**Planning Officer:** Simon Davis

**Planning Application Ref:** FP/171/18/PL

**Location:** Land at Stanhorn Grove, Felpham

**Description of works:** Erection of 18 No. dwellings, creation of new access, landscaping & associated works

SITE LAYOUT

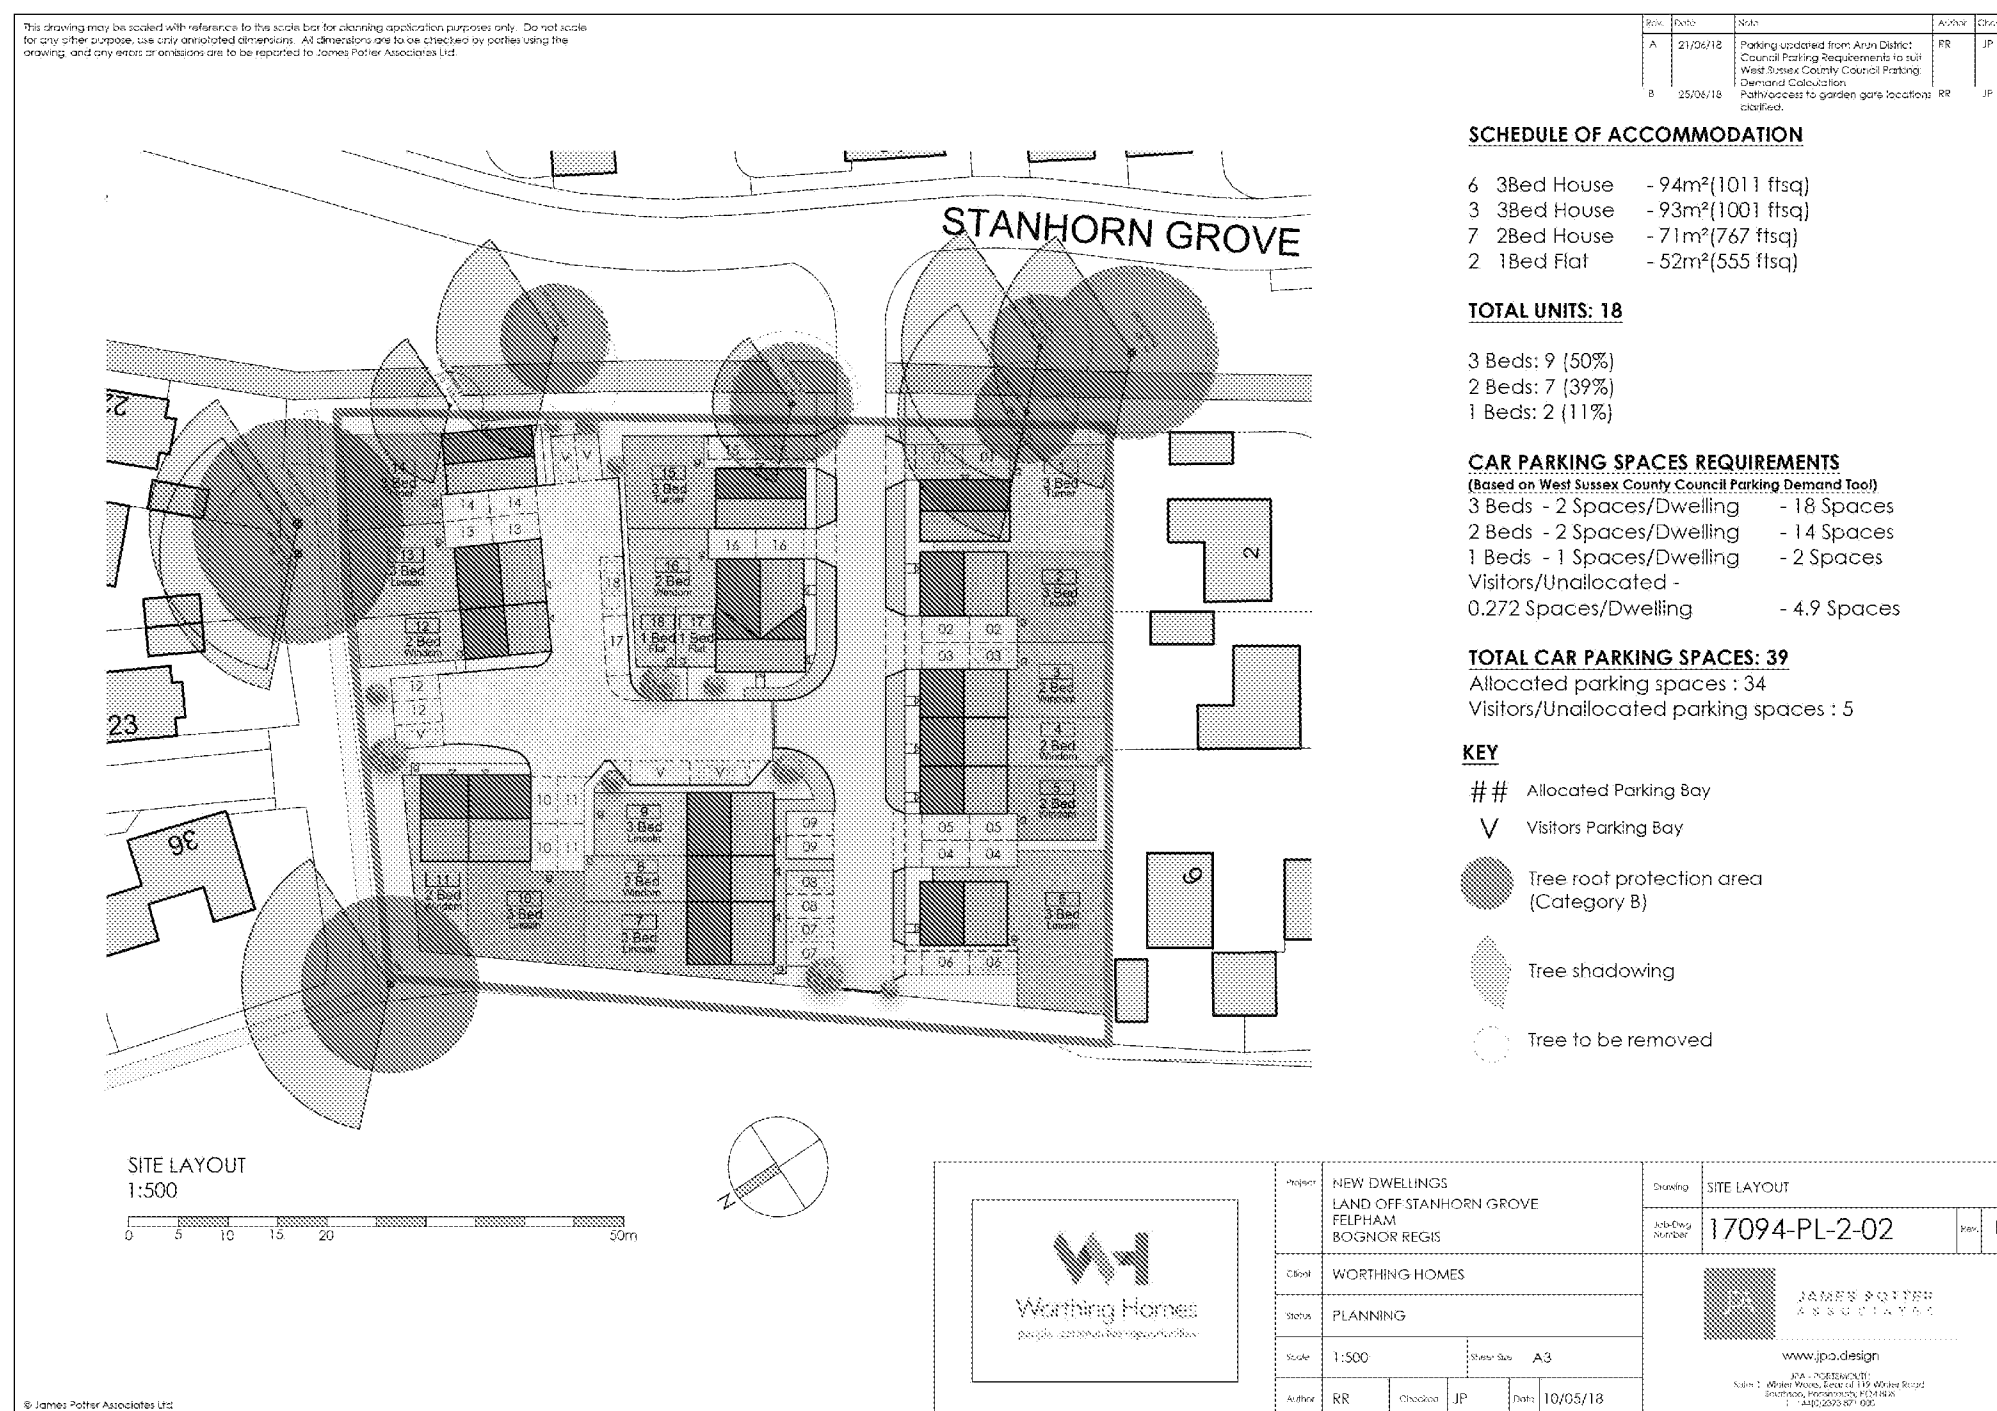
- The latest site layout proposes significant RPA incursion from the construction of driveway/parking areas and main estate access road from the east and/or does not allow for future growth - in respect of oak trees T7, T8 and T11. [Whilst a detailed 'No-dig' solution is proposed, the extent of incursion for T8 appears to exceed the recommended 20% limit of unsurfaced ground within the RPA, although no area calculations have been provided to support viability of such a plan.](#)

- 'Pressure to prune' trees along the east boundary from future residents of plot number 1 should be anticipated, putting at risk the public amenity value they currently provide. A revised layout should be sought that better accommodates existing trees of significant value (T1, T3 and T7). It is disappointing that the design layout does not fully respect the significant trees around this plot. Tree constraints are mostly confined to the site perimeter, therefore it is reasonable to expect the final design to fully respect, accommodate and be in harmony with all Category B and C boundary trees.
- If the applicant can provide a revised site layout which avoids all intrusion of Root Protection Areas, then I would be able to lend this scheme my support.

scheme: Land West of Stanhorn Grove
Felpham
client: Worthing Homes
drawing: Tree Protection Plan
date: October 2018
scale: 1:200@A1
dwg no: PRI21588-03
drawn: RA checked: MW

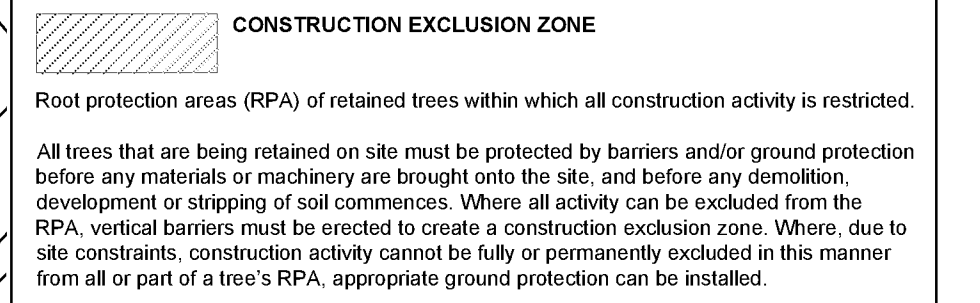
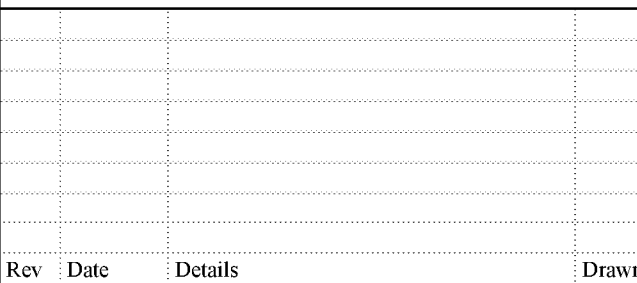
- The applicant has employed ACD Environmental to provide a preliminary Tree Report (Tree survey and constraint advice), ref.PR121588tr, 03/01/2018. I broadly concur with the tree schedule information and retention category ratings. The report contains a strong set of recommendations to their client which I endorse. Specifically, they have identified the need for a more detailed AIA which I would expect to be inclusive of a Tree Removal and Retentions Plan and importantly a Tree Protection Plan and specific Arboricultural Method Statement. [The applicant has now submitted an Arboricultural Impact Assessment and Method Statement from ACD Environmental, ref: PR121588aia-ams, 08/10/2018, inclusive of a Tree Protection Plan, ref: PR121588-03, which also highlights those trees proposed for pruning or removal.](#)
